# **AQUIND INTERCONNECTOR**

## **Schedule of Changes Submitted for Deadlines 7c and 8**

Document Ref: 7.2.8

**DATE: 1 MARCH 2021**

**4.8. SCHEDULE OF CHANGES FOR DOCUMENT 6.2.15.49 ENVIRONMENTAL STATEMENT - VOLUME 2 - FIGURE 15.49 INDICATIVE LANDSCAPE MITIGATION PLAN OPTION B(I) (SOUTH) - REV. 05**

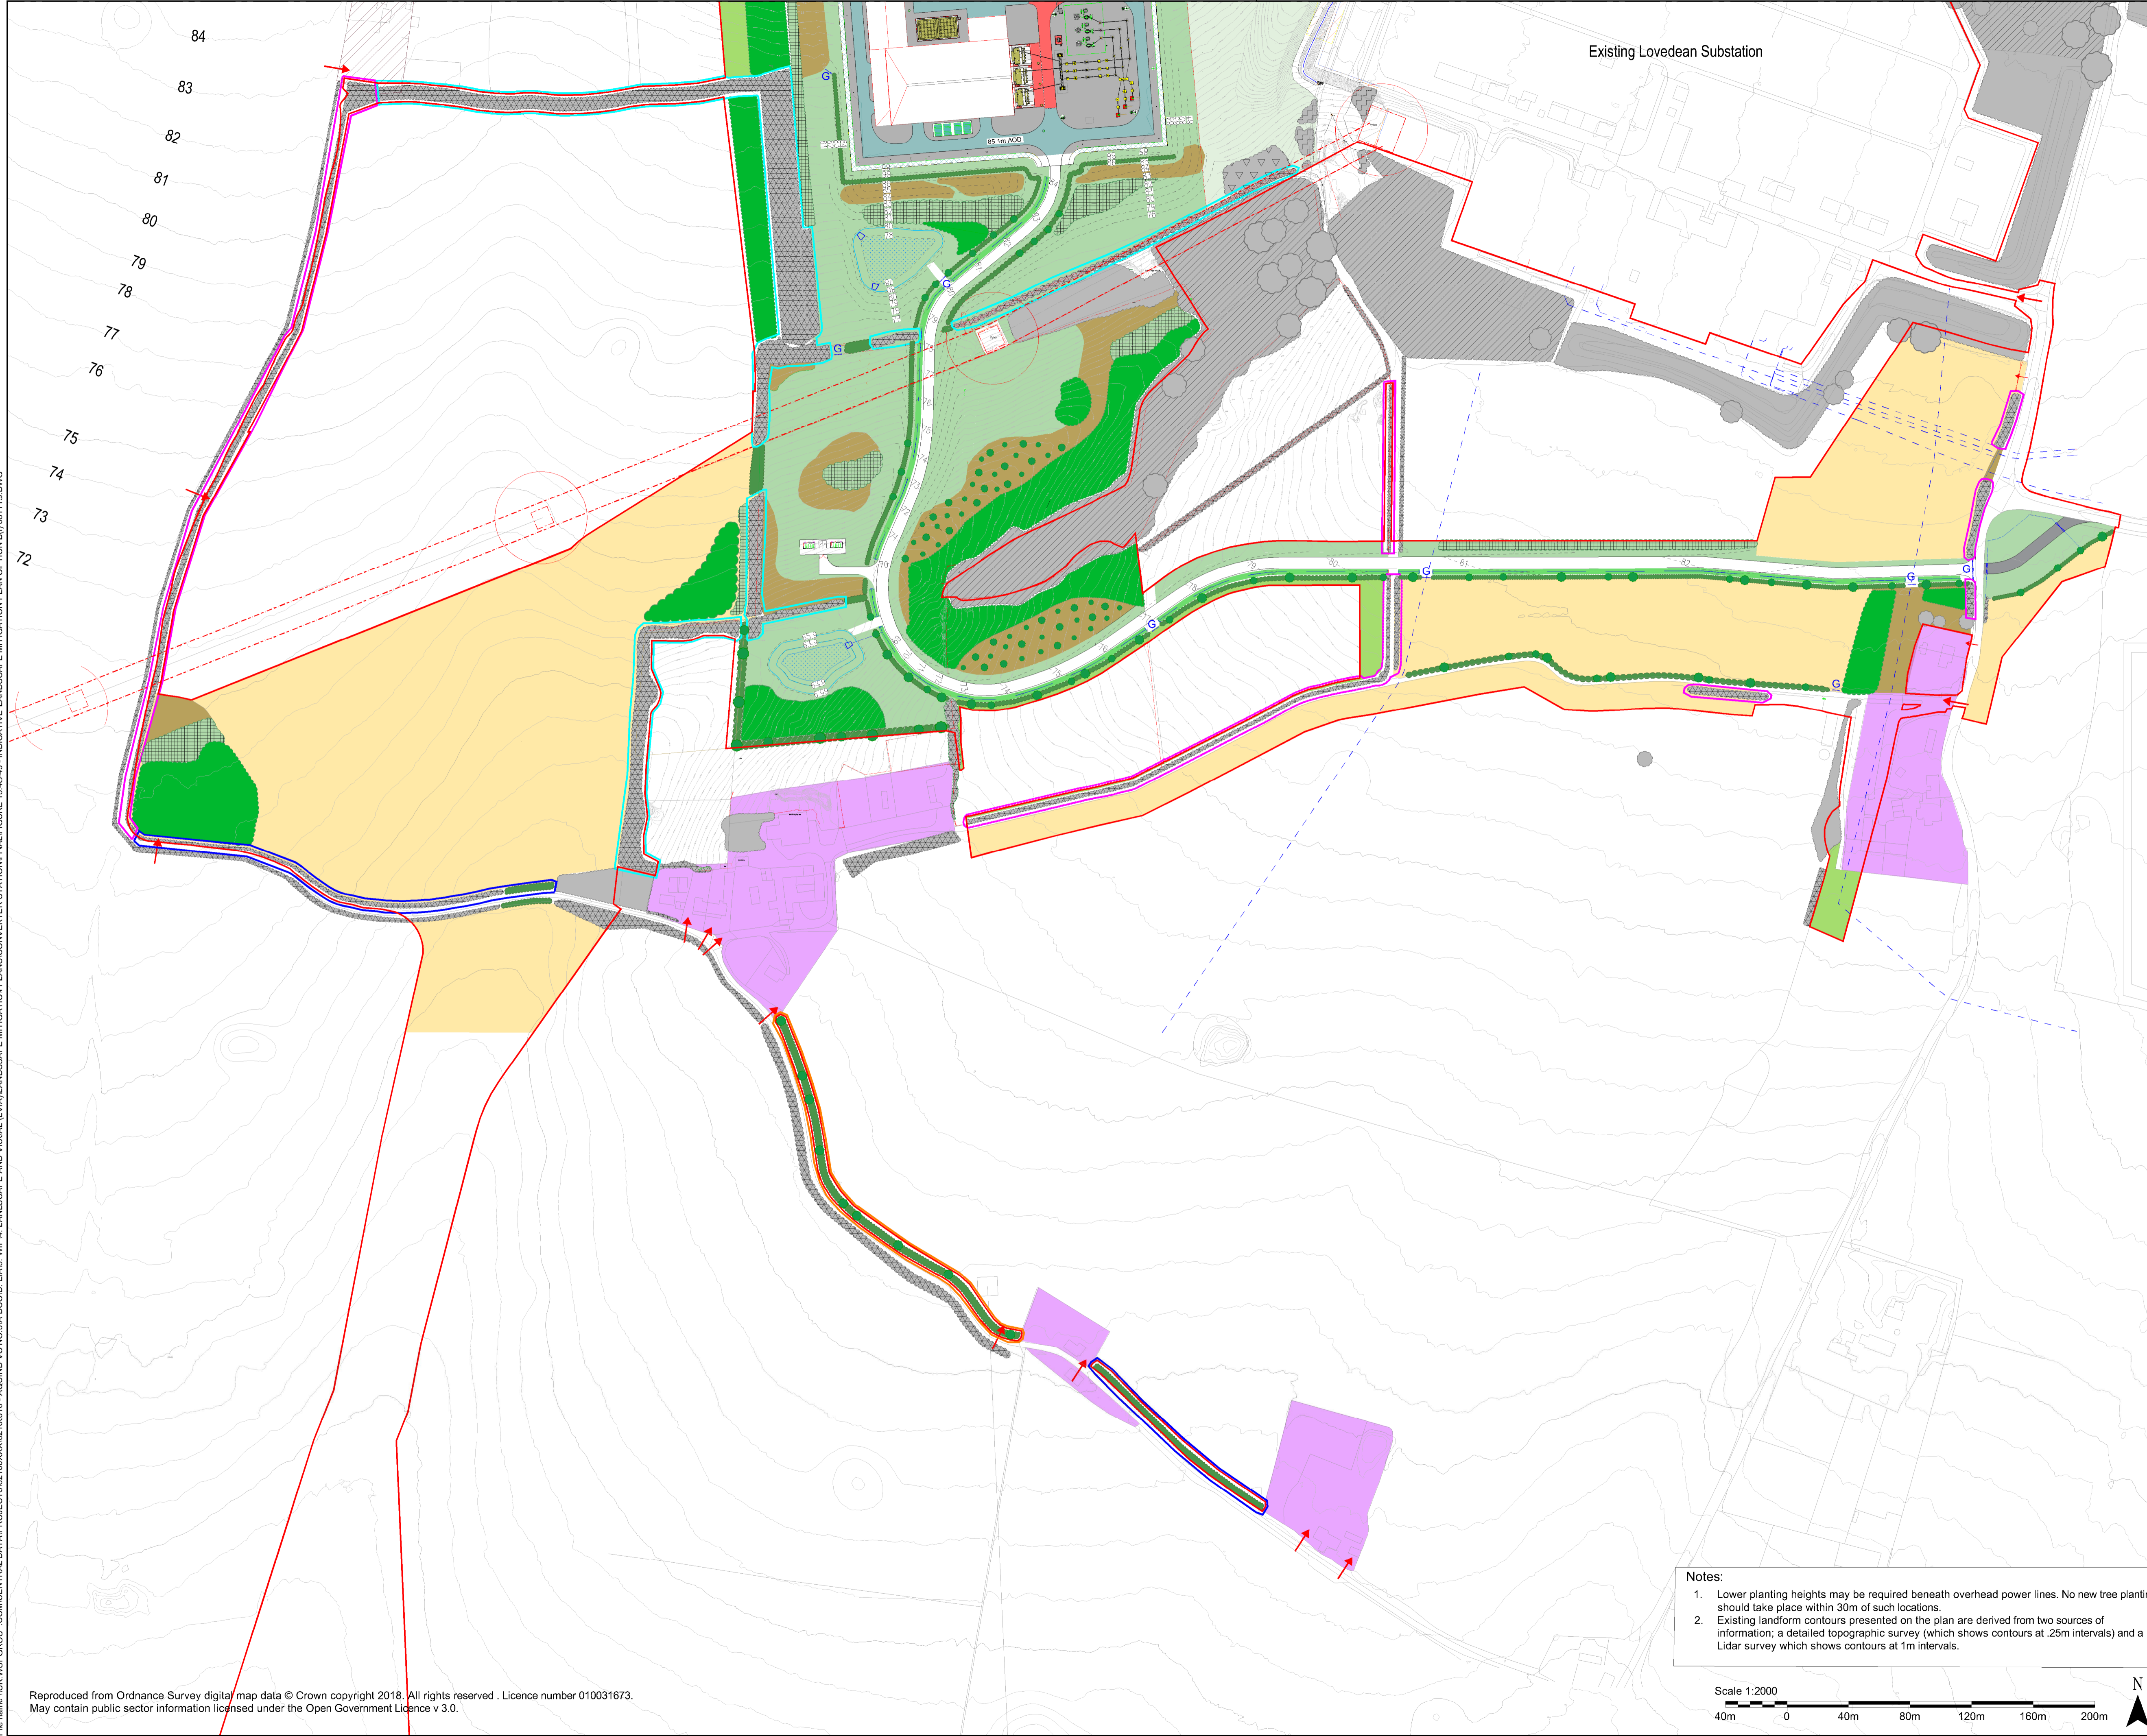
Reference	Change	Reason for Change
<b>General</b>	Update from Rev 04 to Rev 05.	Updated in line with comments received from SDNPA at Deadline 7c
<b>Key</b>	Update to key	Addition to key further to SDNPA request at deadline 7c Replacement planting will take place within existing woodland, hedgerows and in relation to individual mature trees

Plate 6 - Proposed construction traffic management on Day Lane - will be replaced with full page image when issued as PDF

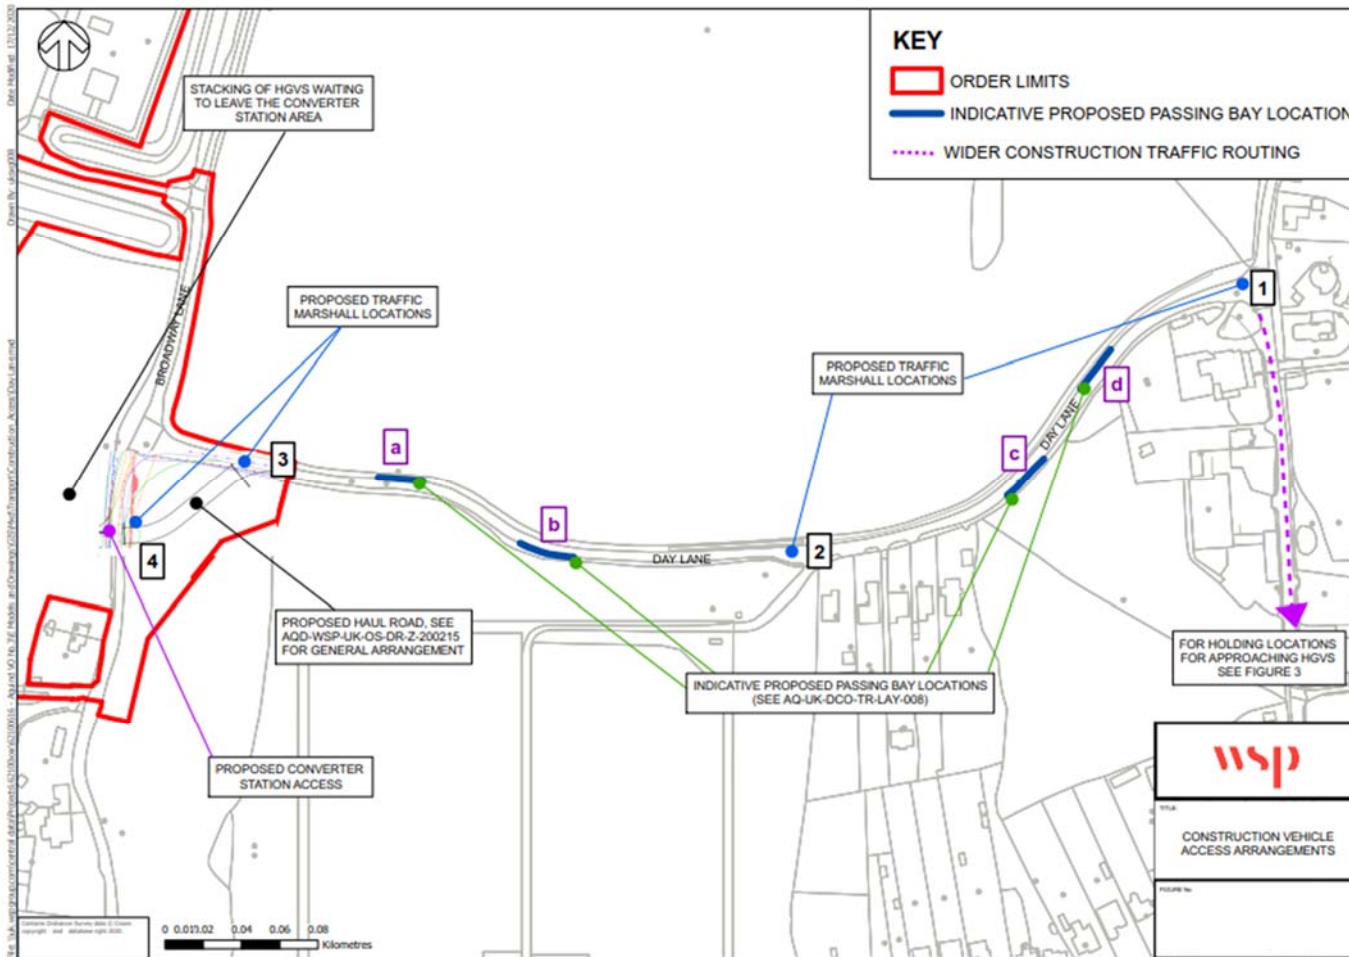
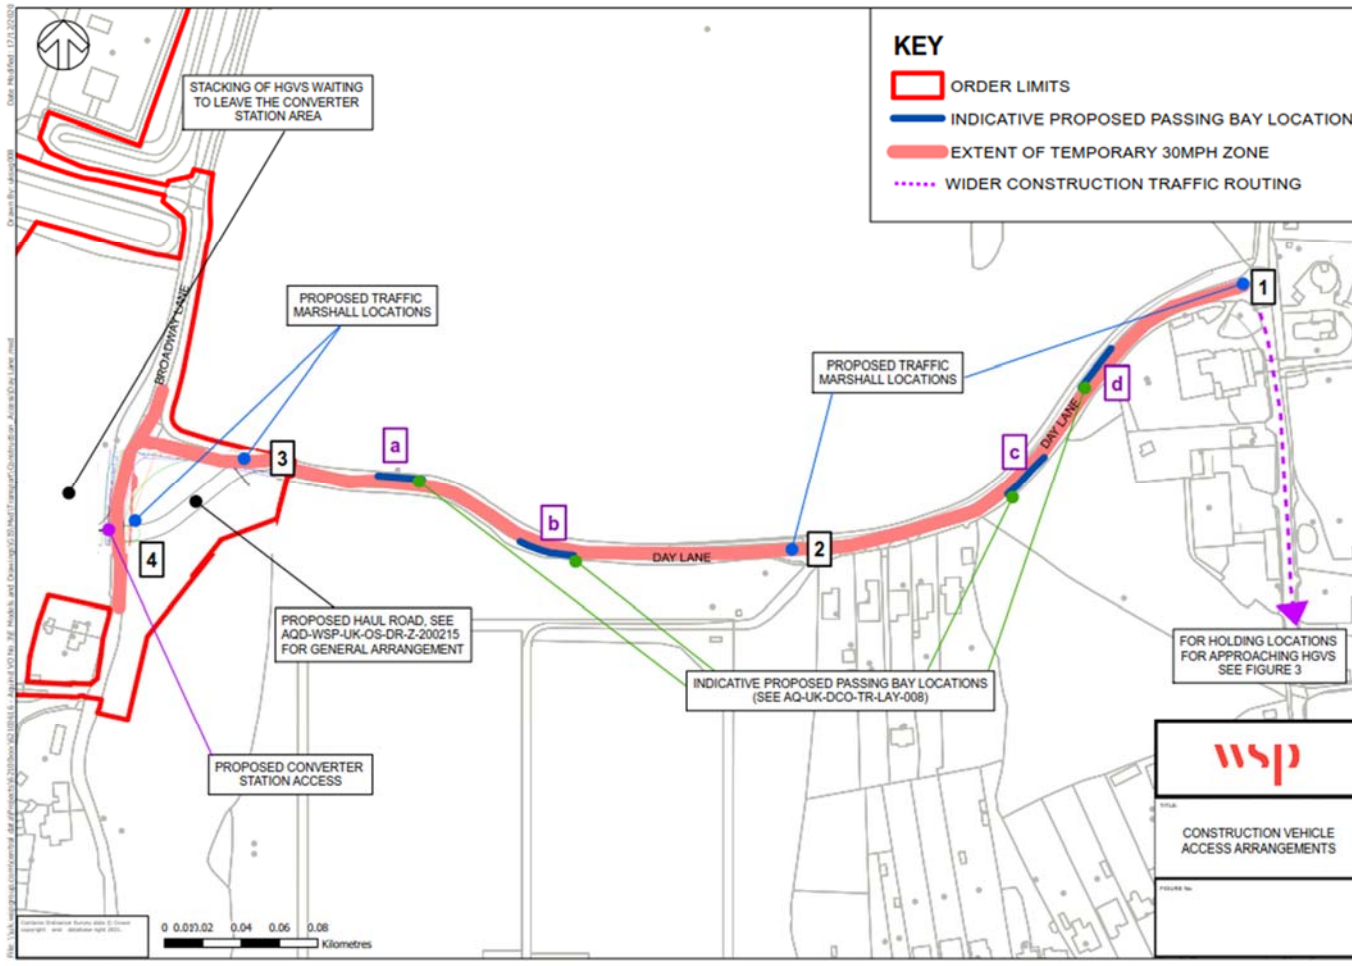
<b>Appendix 5</b>	Inclusion of AIL Route Access Study	Requested by HCC
<b>Appendix 7</b>	Updates to Framework Construction Worker Travel Plan	Amendments made to reflect discussions with highway authorities and final agreed position.
<b>Appendix 9</b>	Inclusion of all highway interventions associated with management of	Amendments made to reflect discussions with highway authorities and final agreed position.
